Consultation Response from KC, Lead Local Flood Authority
2024/91007 adj, 208, Yew Tree Road, Birchcliffe, Huddersfield, HD2 2EQ
Discharge of conditions 6 (Phase II report), 7 (Remediation Strategy), 10 (affordable housing), 11 (public open space), 12 (education), 13 (sustainable transport), 14 (temporary drainage), 16 (drainage scheme), 17 (attenuation and discharge rate), 18 (access point), 19 (estate roads), 21 (footway details), 23 (construction management plan), 24 (noise report), 25 (ecological design strategy) and 26 (electric vehicle charging) of previous permission 2018/90151 for outline application for erection of residential development
Date Responded: 8th May 2025
Responding Officer: Paul Farndale
Responding Ref: 7

Conditions 16 & 17 – Drainage Details and Attenuation

Further to our comments of the 14th April 2025.

TITLE
**OVERALL SITE
PRIVATE DRAINAGE
LAYOUT PLAN**

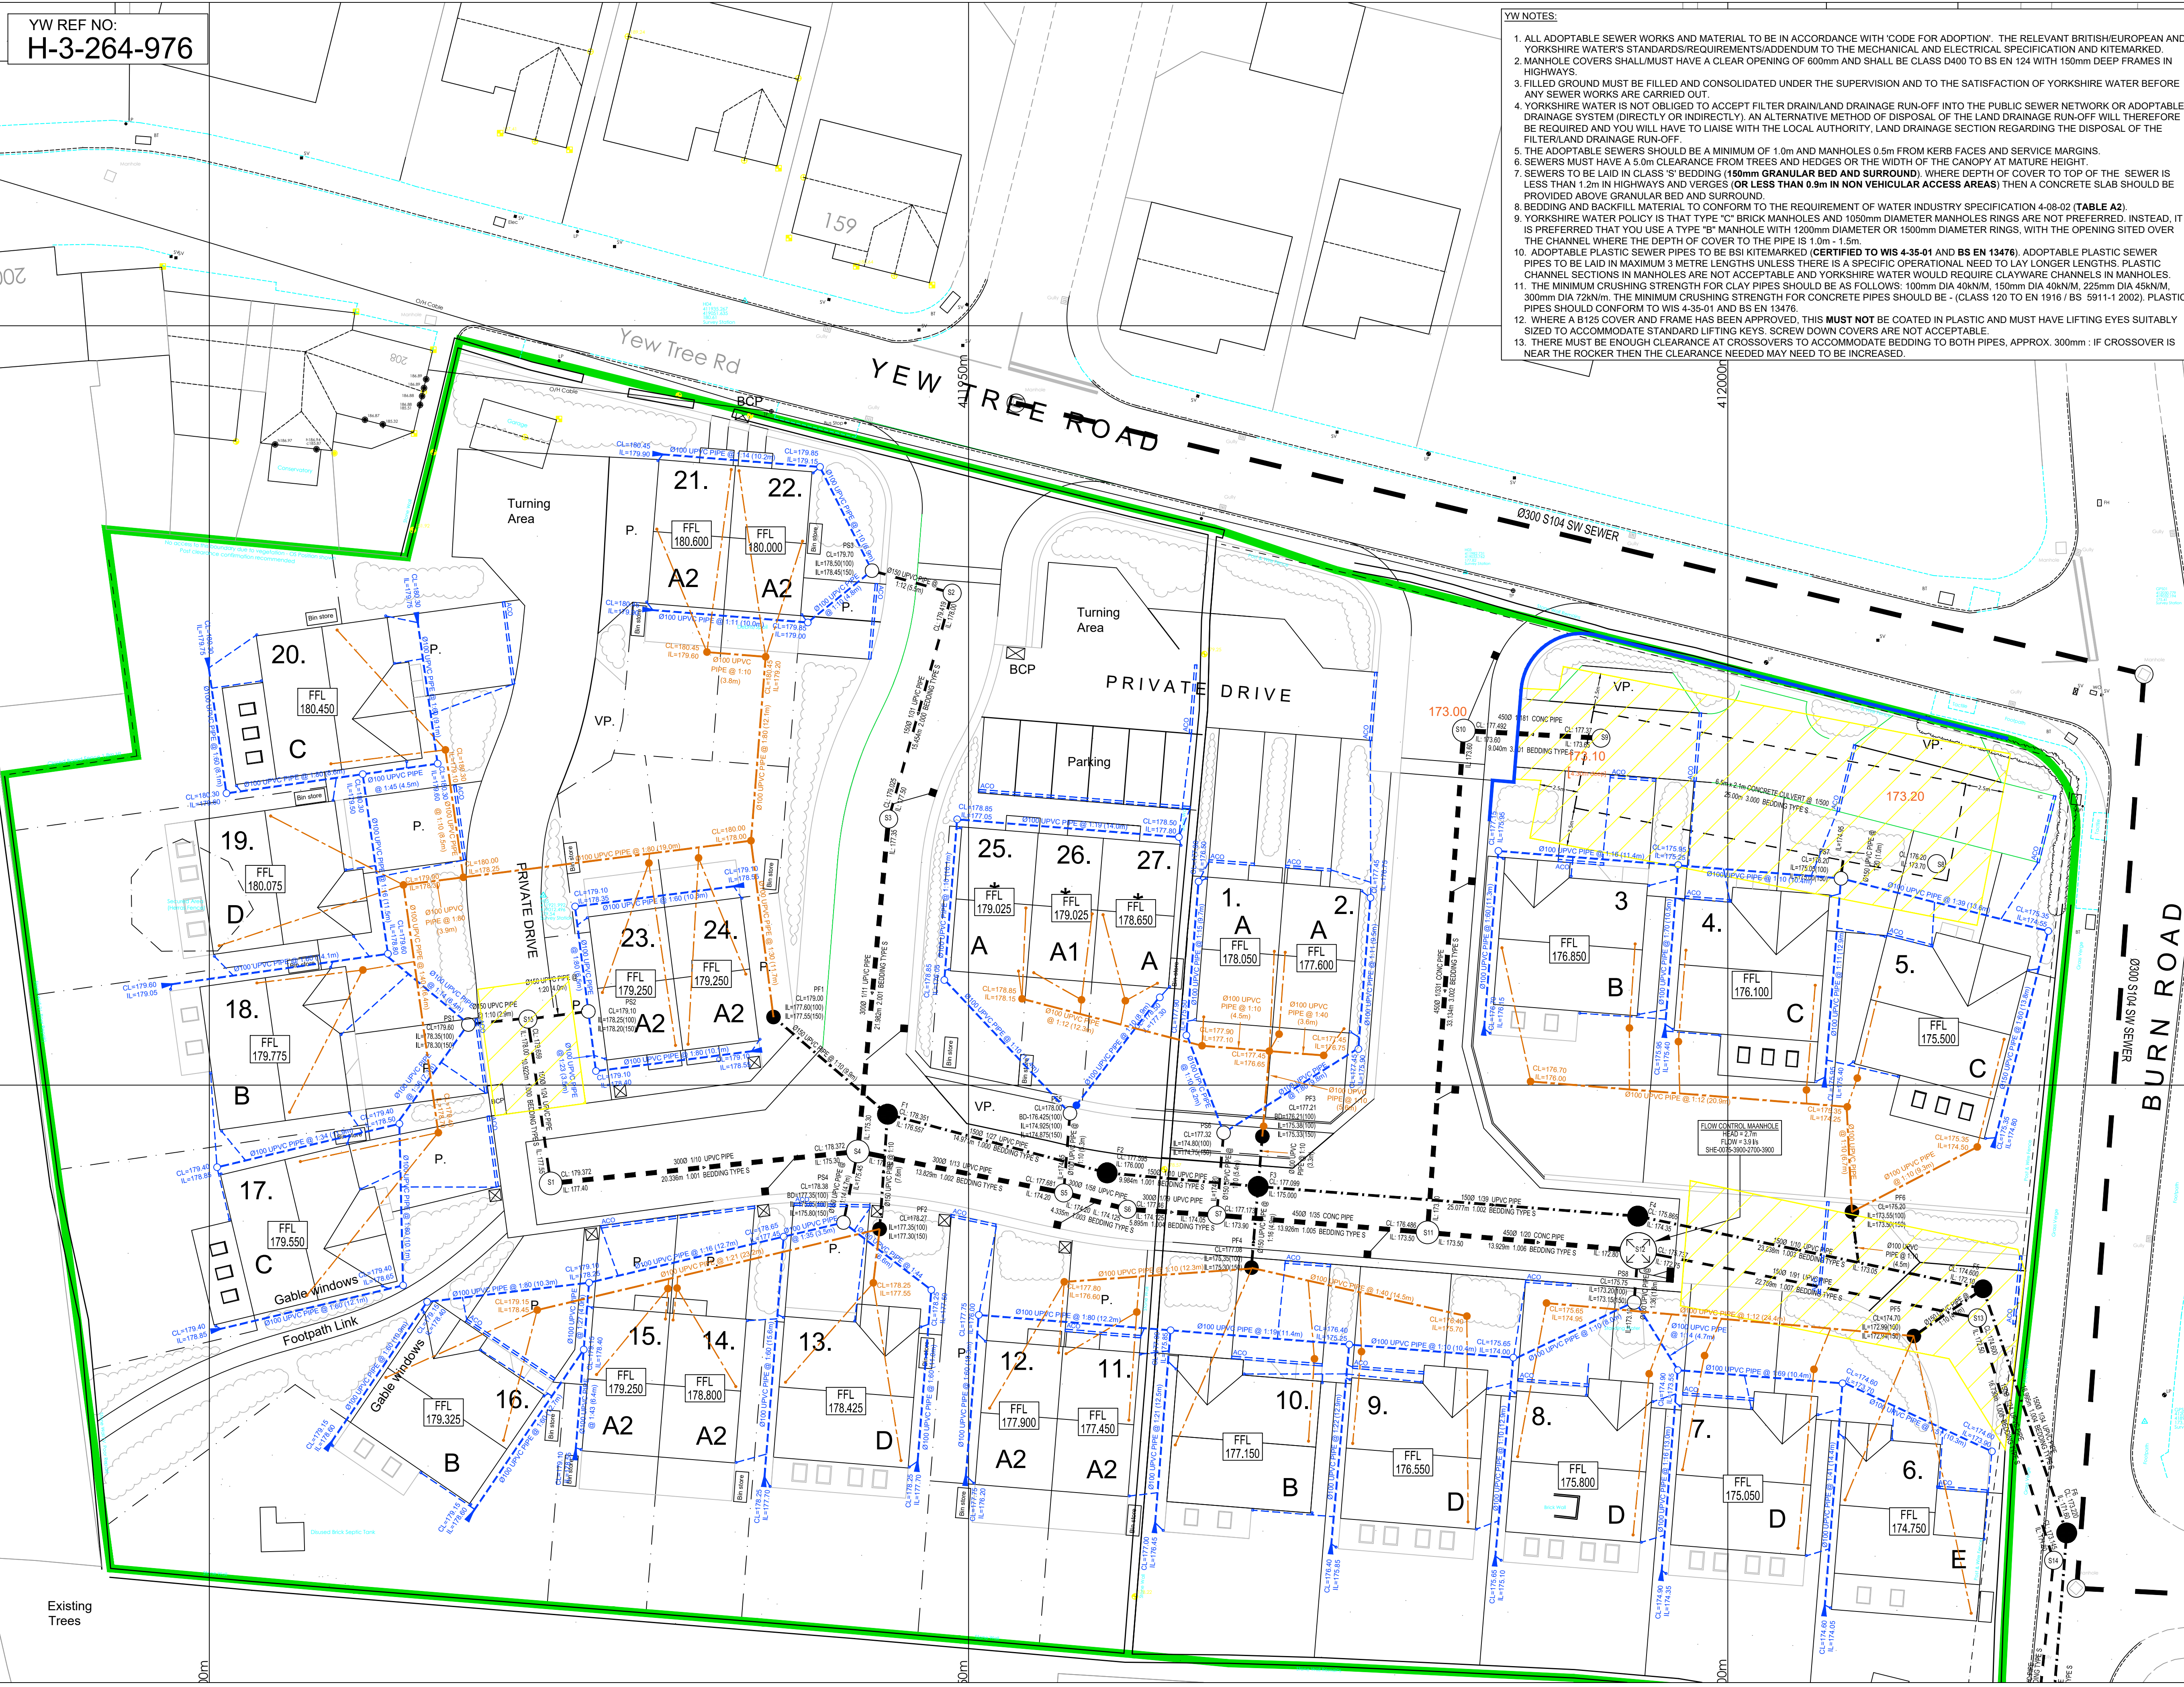
Private Sewer Drainage Layout 22046 118 Rev J

All manhole levels previously raised as different on various drawings are now consistent and match those in longitudinal sections and hydraulic simulations.

We can recommend that these conditions be discharged.

TITLE  
**S104 DRAINAGE  
LAYOUT PLAN**

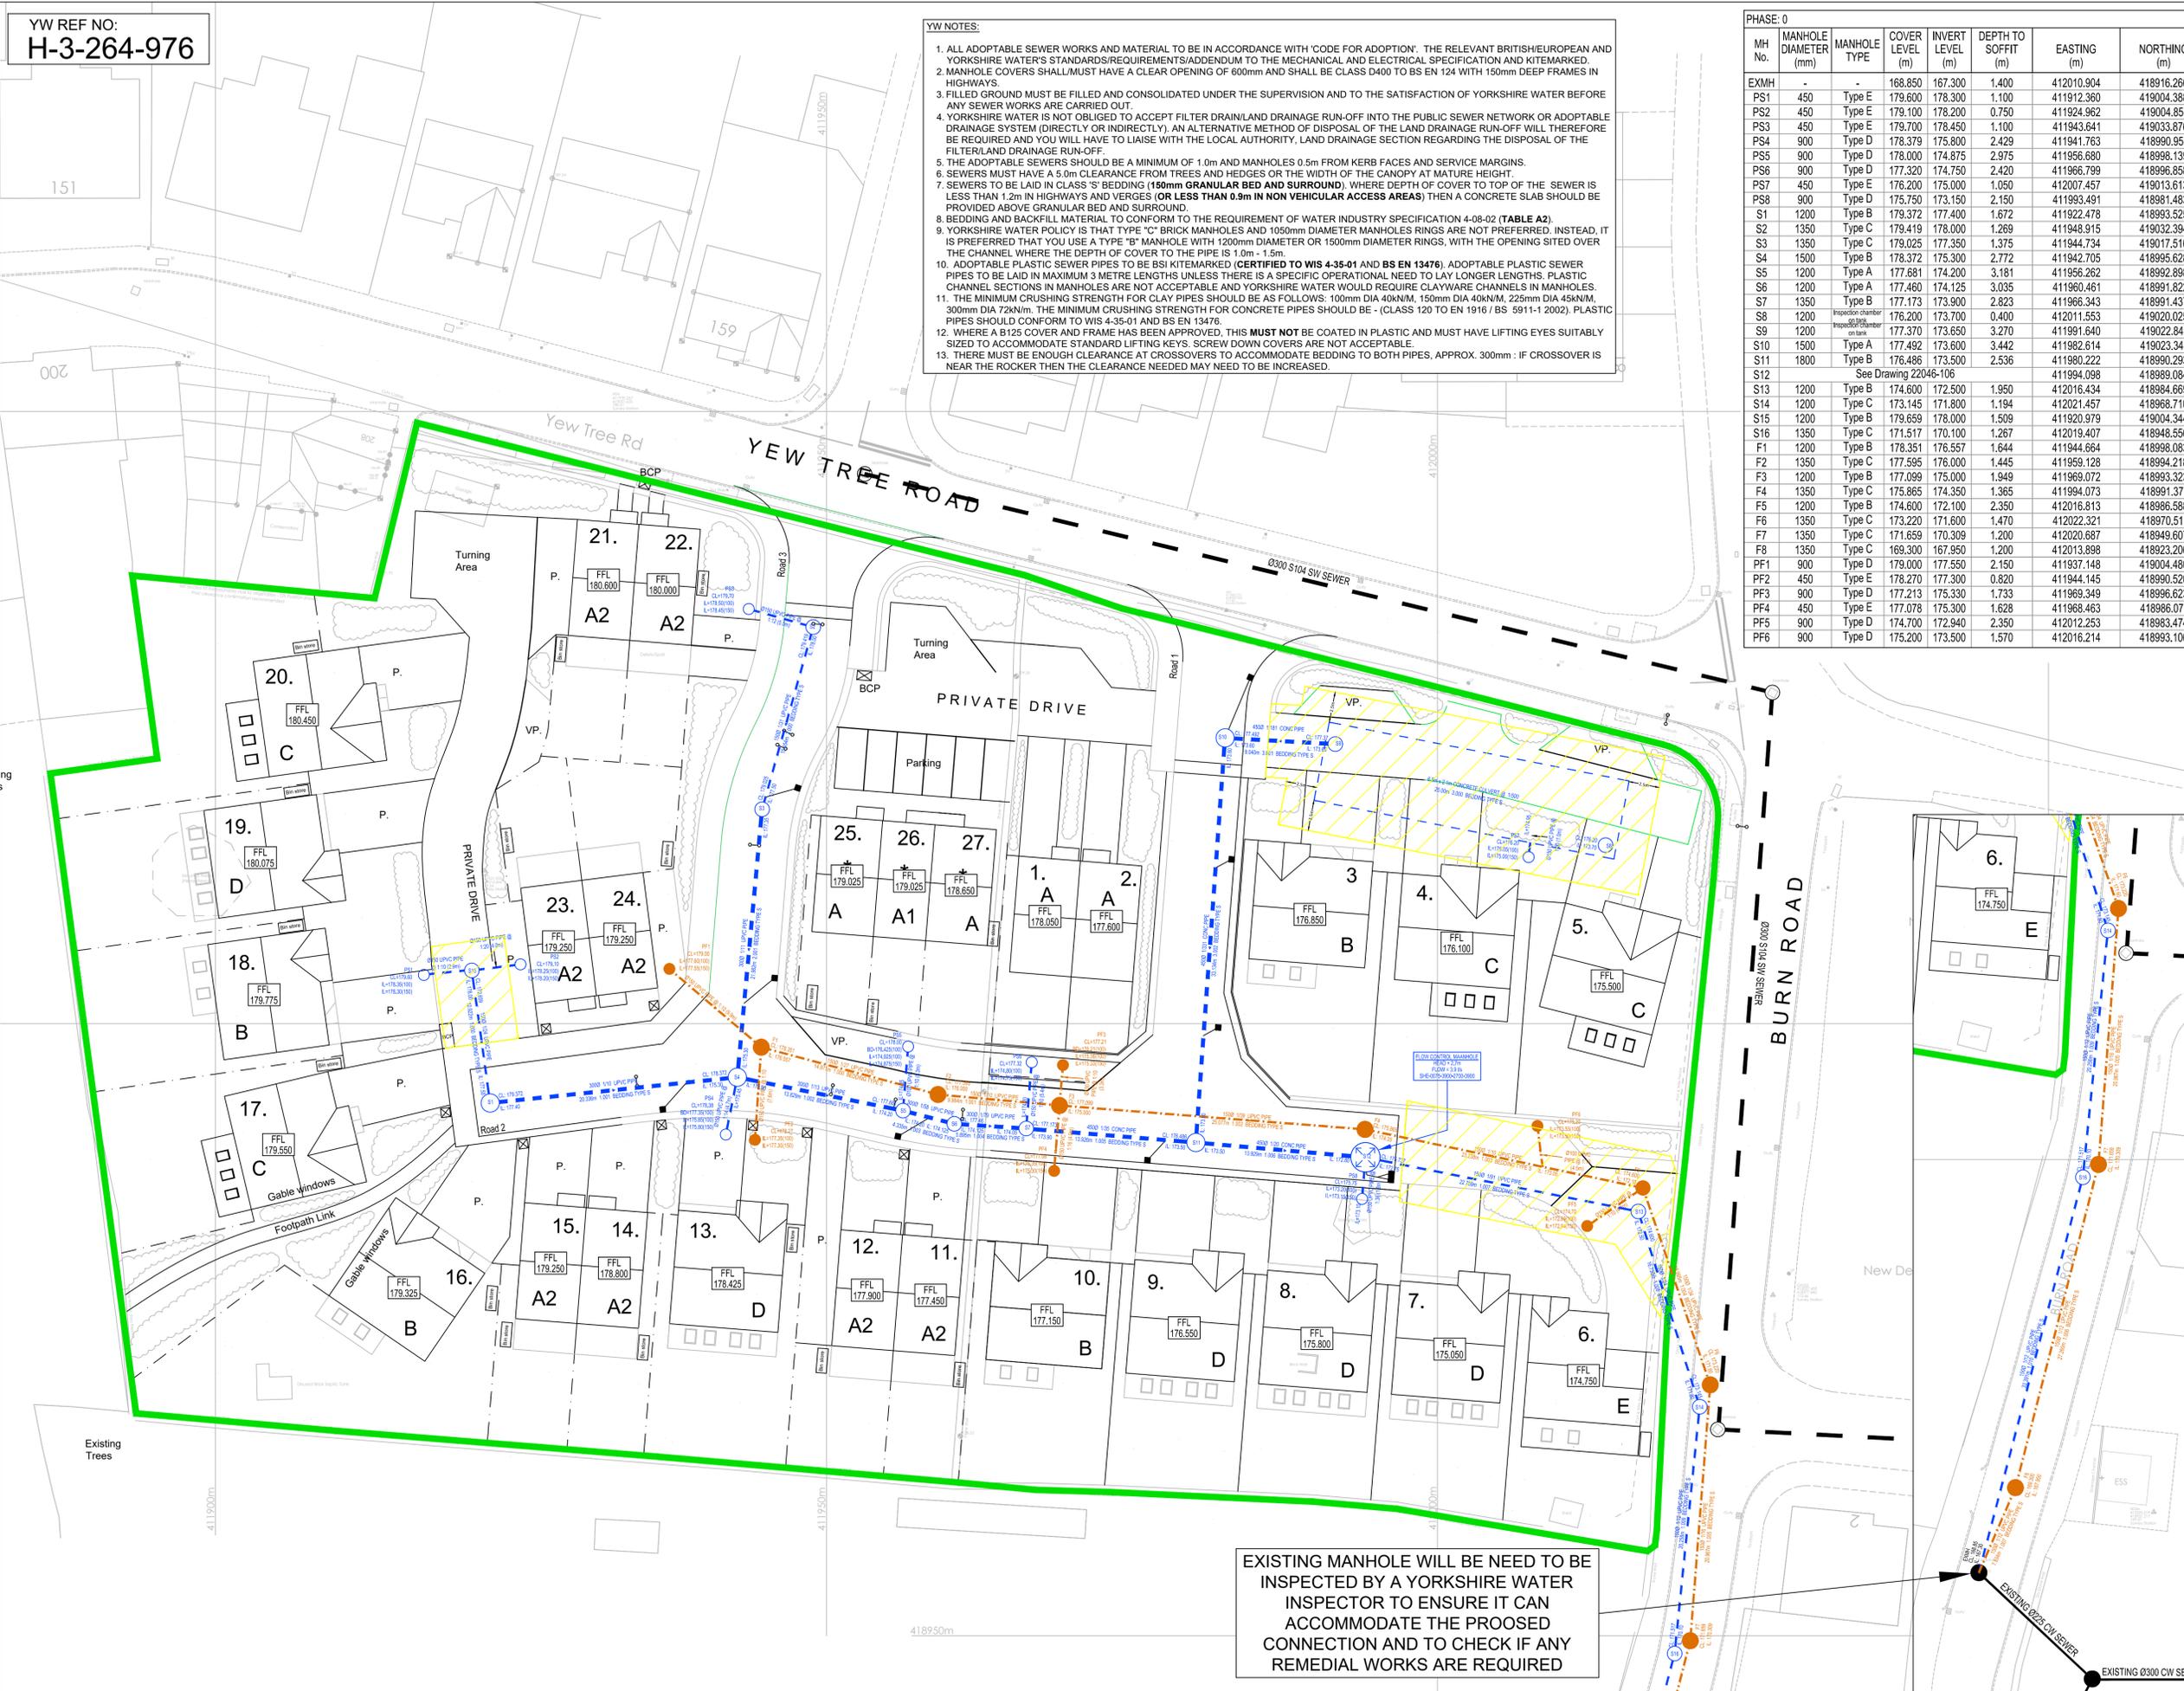
Overall Site Sewer Layout 22046 113 Rev P

DRAWING TITLE: YEW TREE ROAD, BIRCHENCLIFFE
2.1m Dp. MODULAR WATER
RETAINING TANK
PROPOSAL DRAWING

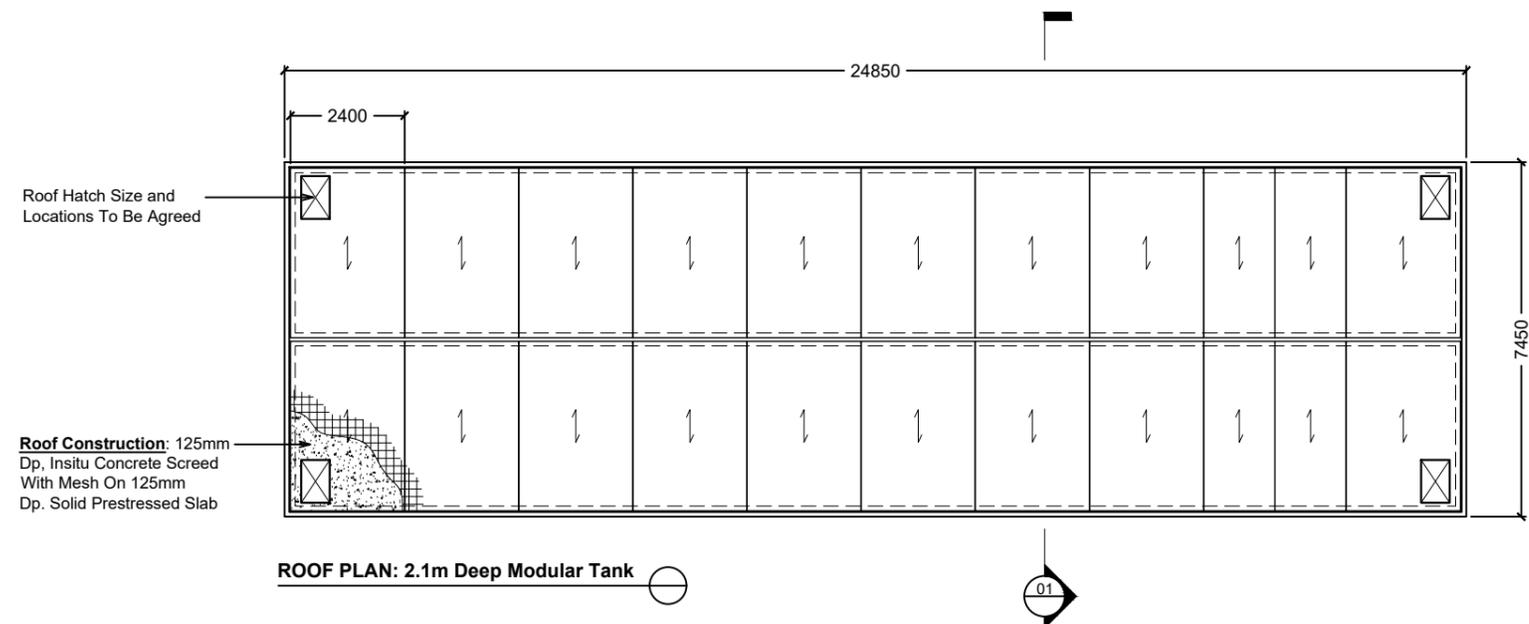
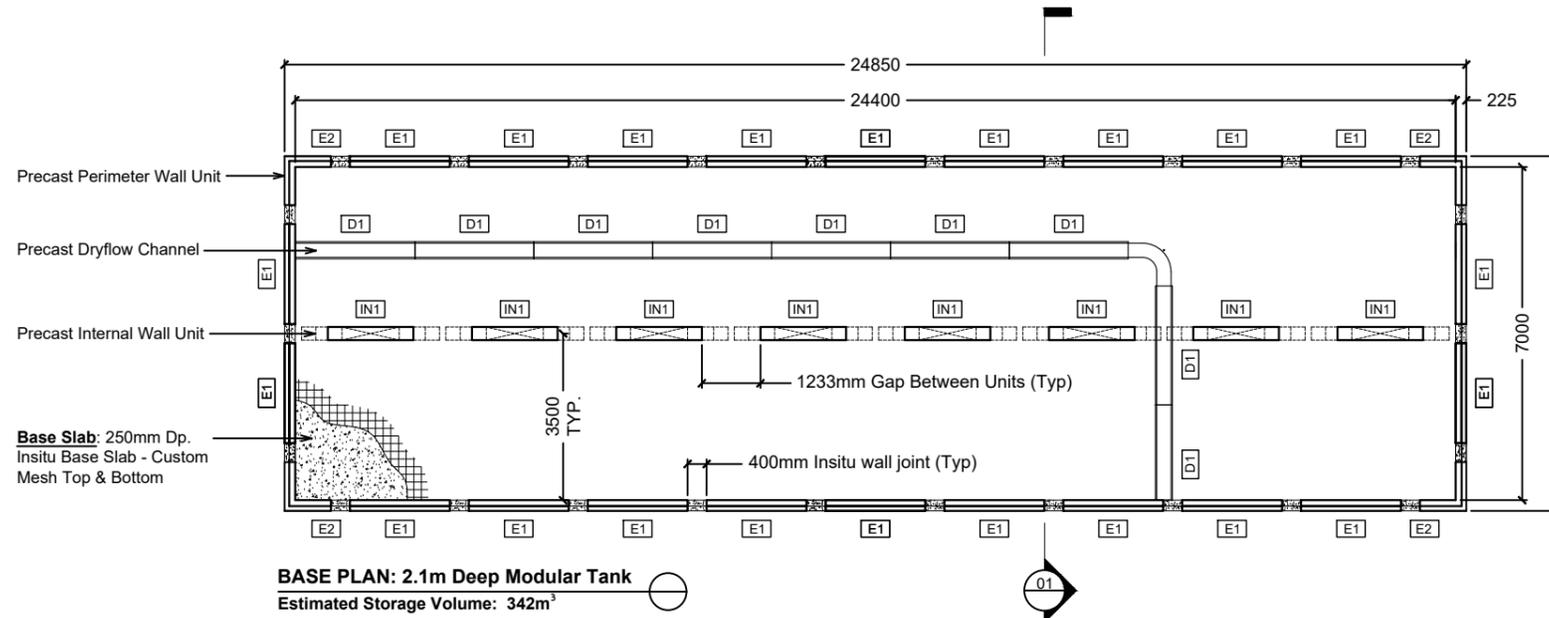
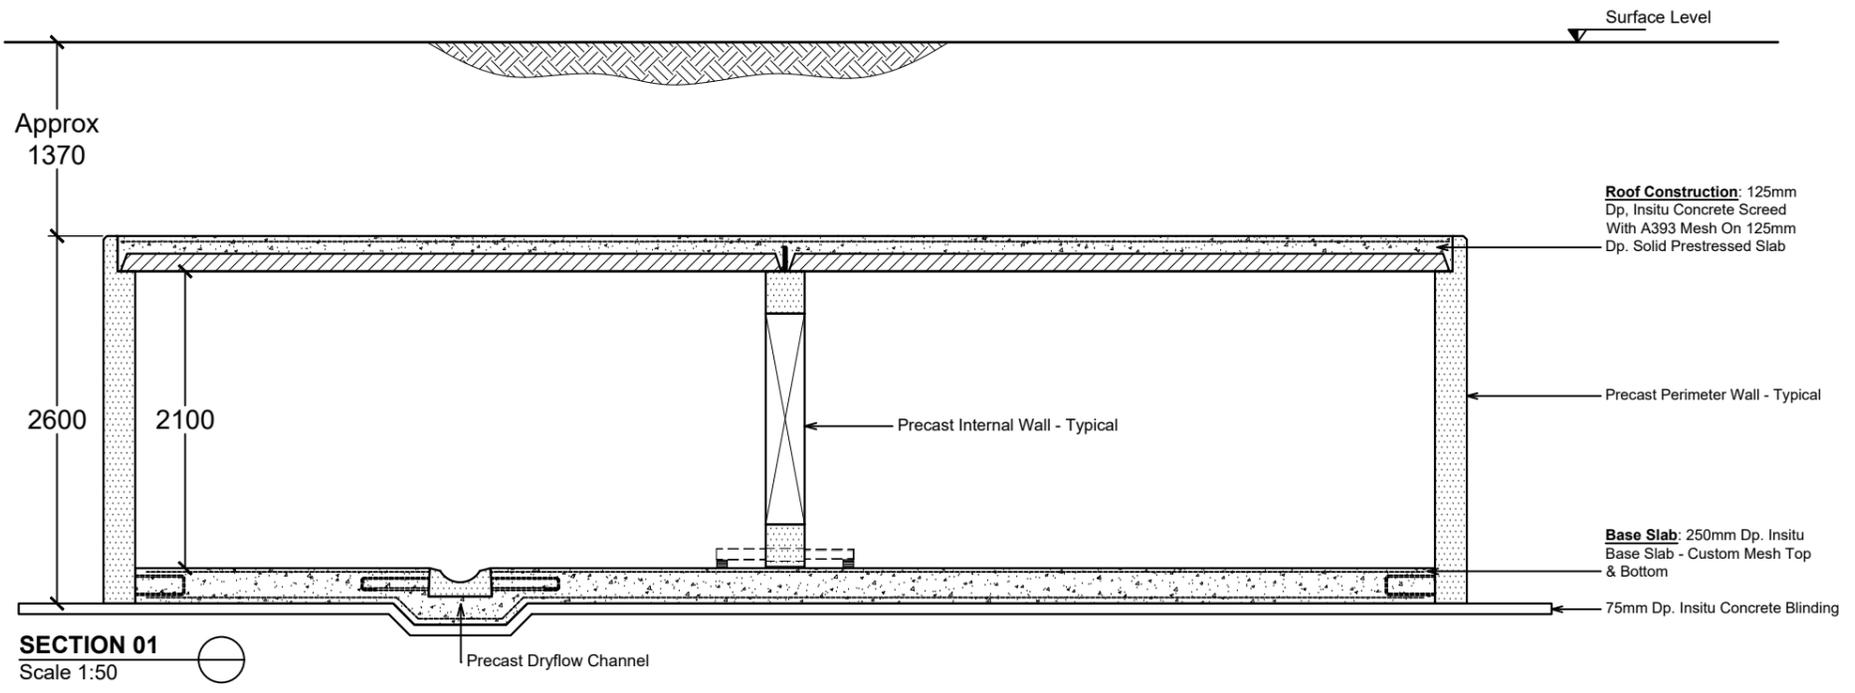
Details of the tank have been provided as requested.
